Application Reference: FG/6/26/PL

Site: Little Twittens Recreation Ground

Proposal: Installation of new double non turf cricket training strip

Sport England Reference: PA/26/SE/AR/73107

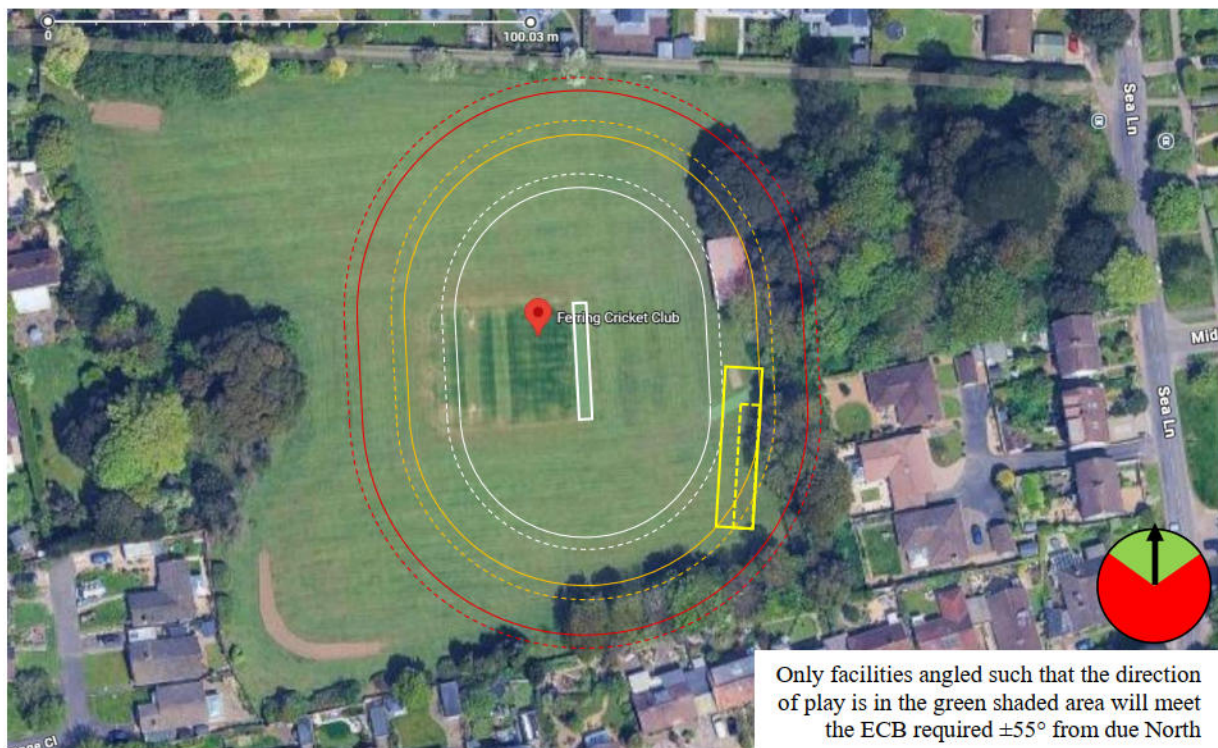
There is also inconsistency between the proposed block plan (30x5.48m) and what Slatters/NottsSport have quoted for (7.66m wide).

CLIENT:	FERRING CRICKET CLUB
PROJECT:	ARTIFICIAL DOUBLE CRICKET PITCH
LOCATION:	SEA LANE, FERRING, BN12 5DY
DRAWING:	PROPOSED BLOCK PLAN
REFERENCE:	NSFCC003
REVISION:	A
DATE:	09/02/26
AUTHOR:	JP
SCALE:	1:500 @A1

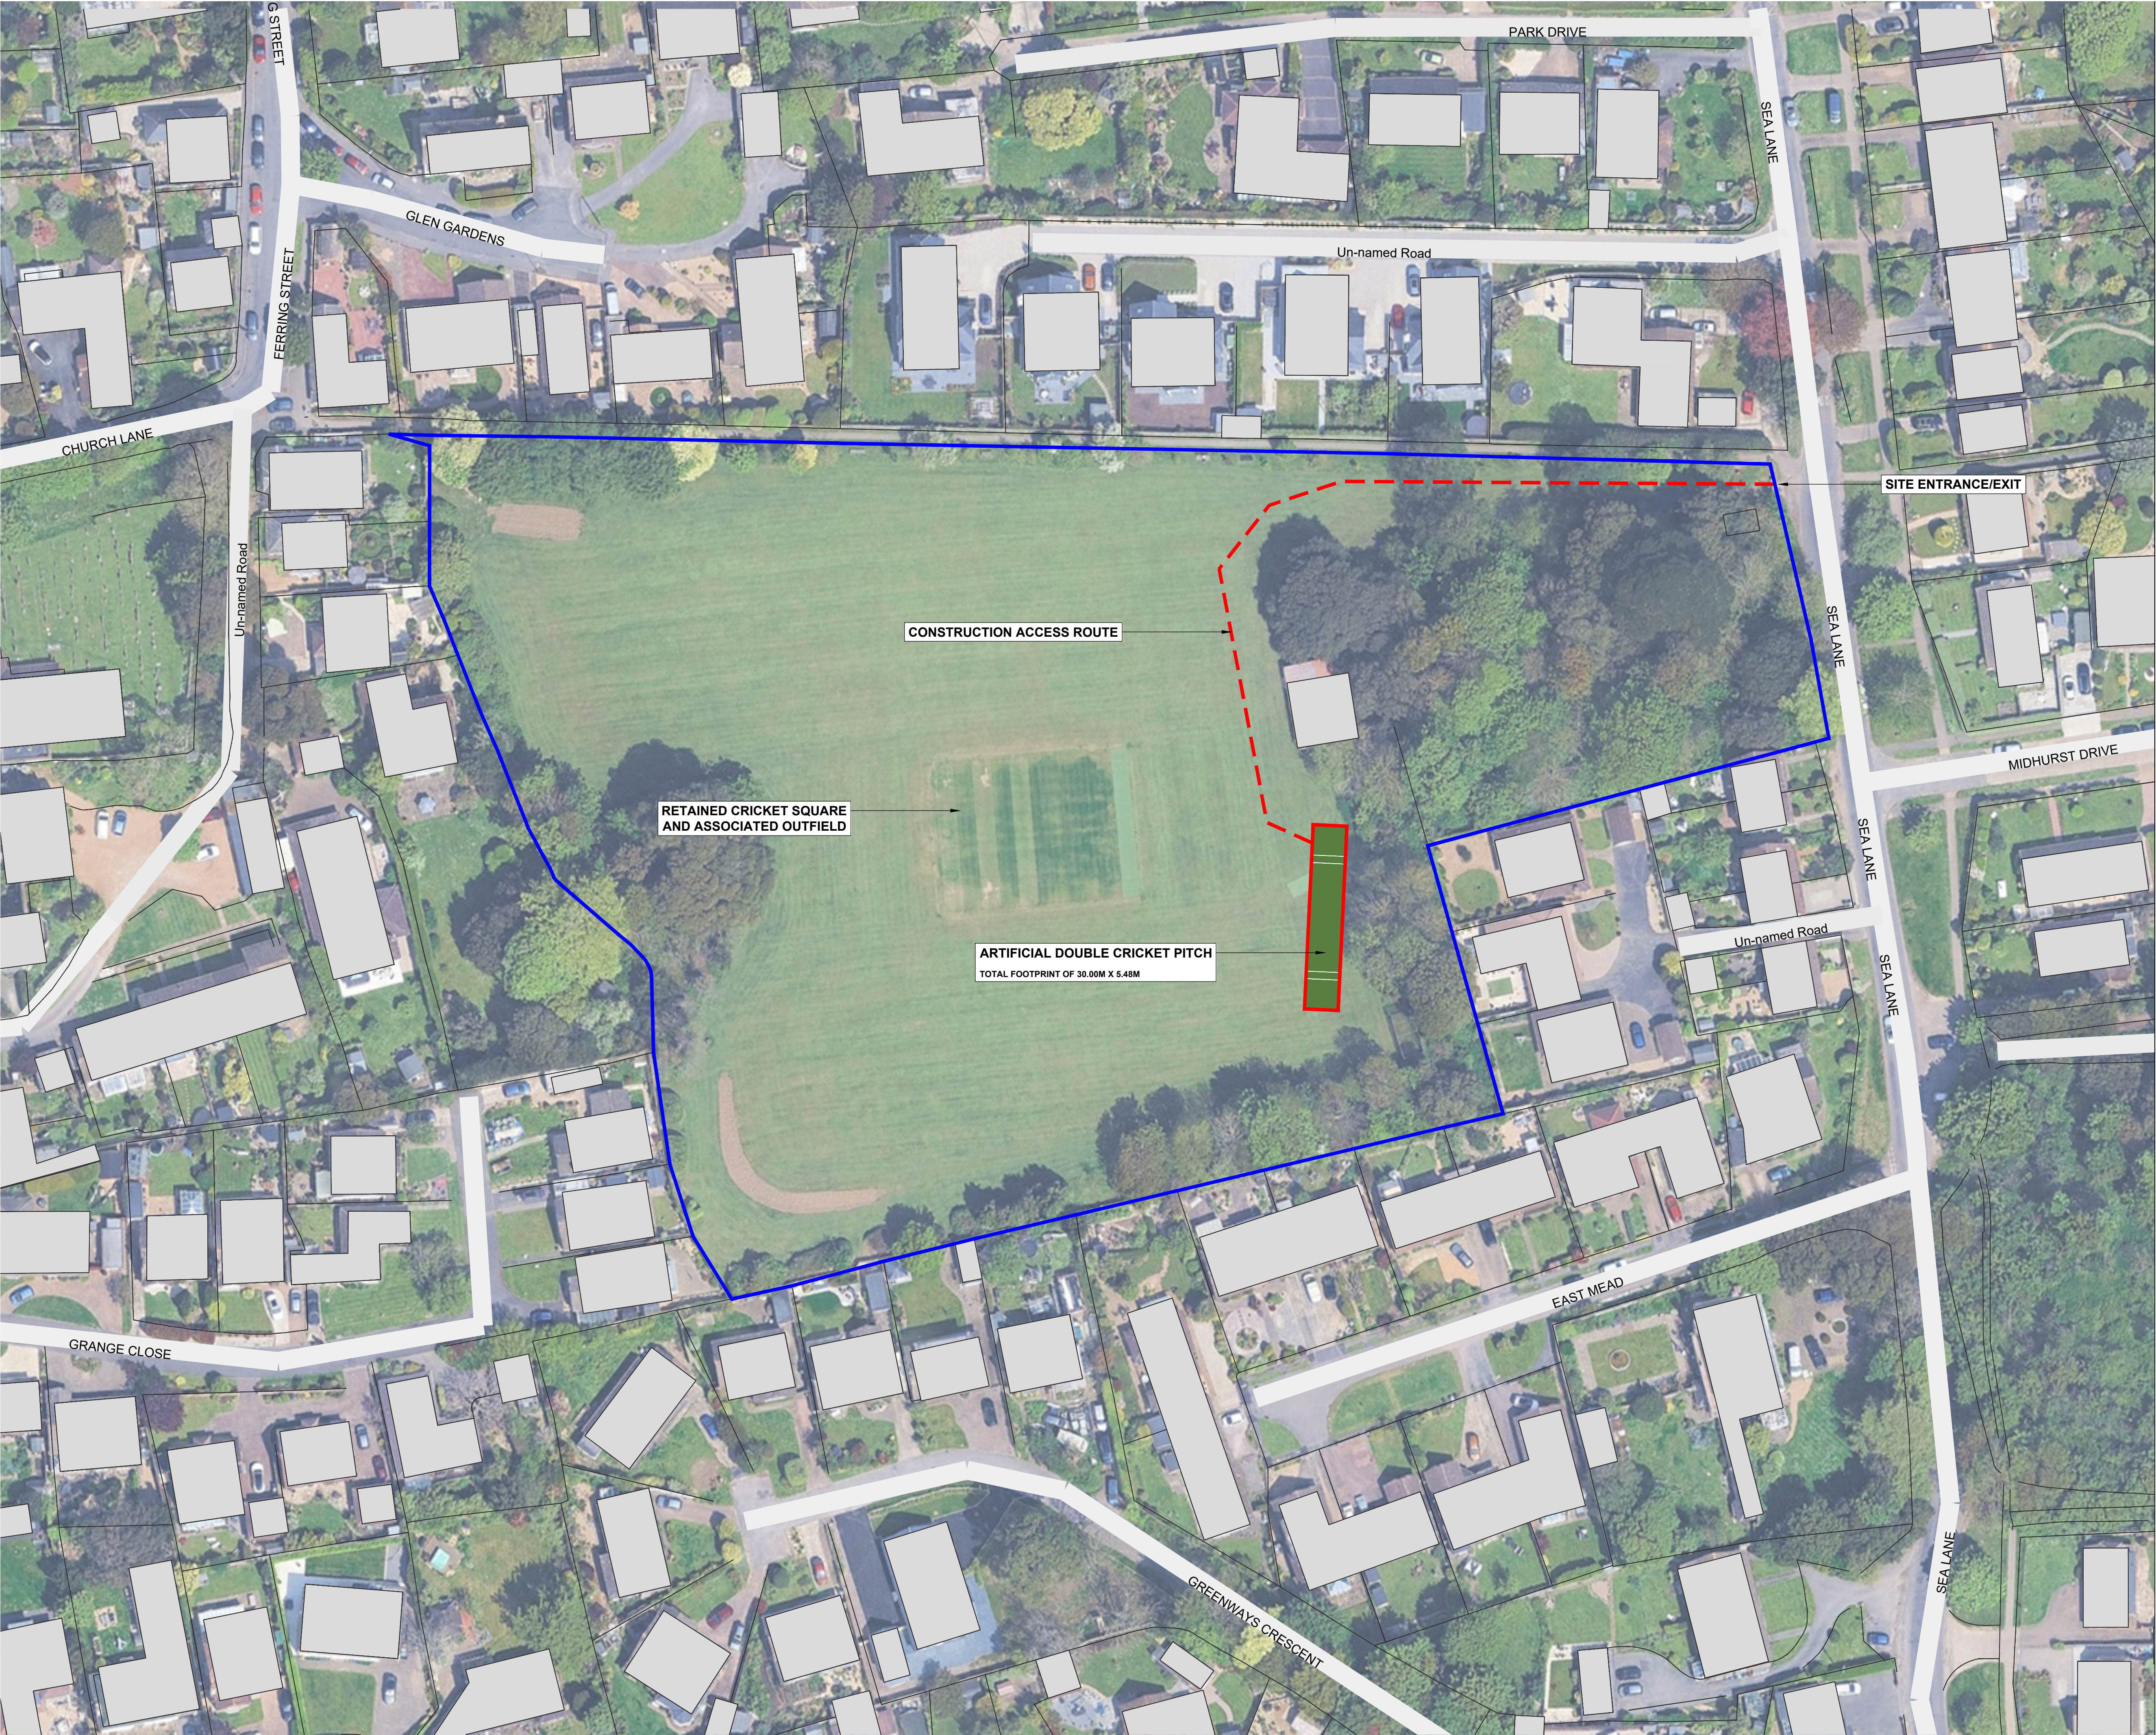
The proposal is as described in full in the planning application. The strip would be sited in the southeast corner of the recreation ground and have an overall footprint of 30m x 5.48m as annotated on the proposed block plan.

The proposal as presented is unsuitable, having a significant impact (de facto loss of playing field = 230m²) on the limited existing boundary – from fine turf pitches, as well as the existing, non-compliant (24m) non-turf pitch (NTP). The new surface being approximately just 28m from the NTP, significantly less than the absolute minimum recommended boundary for junior cricket (37m + 2.74m runoff).

The ECB advises the club to engage with their supplier and Sussex Cricket Foundation towards a fit-for-purpose installation and location on-site. For example, the NW and SW of the ground would both be potential locations for a non-turf practice facility, sitting comfortably outside of the boundary, and within the limits of good orientation.
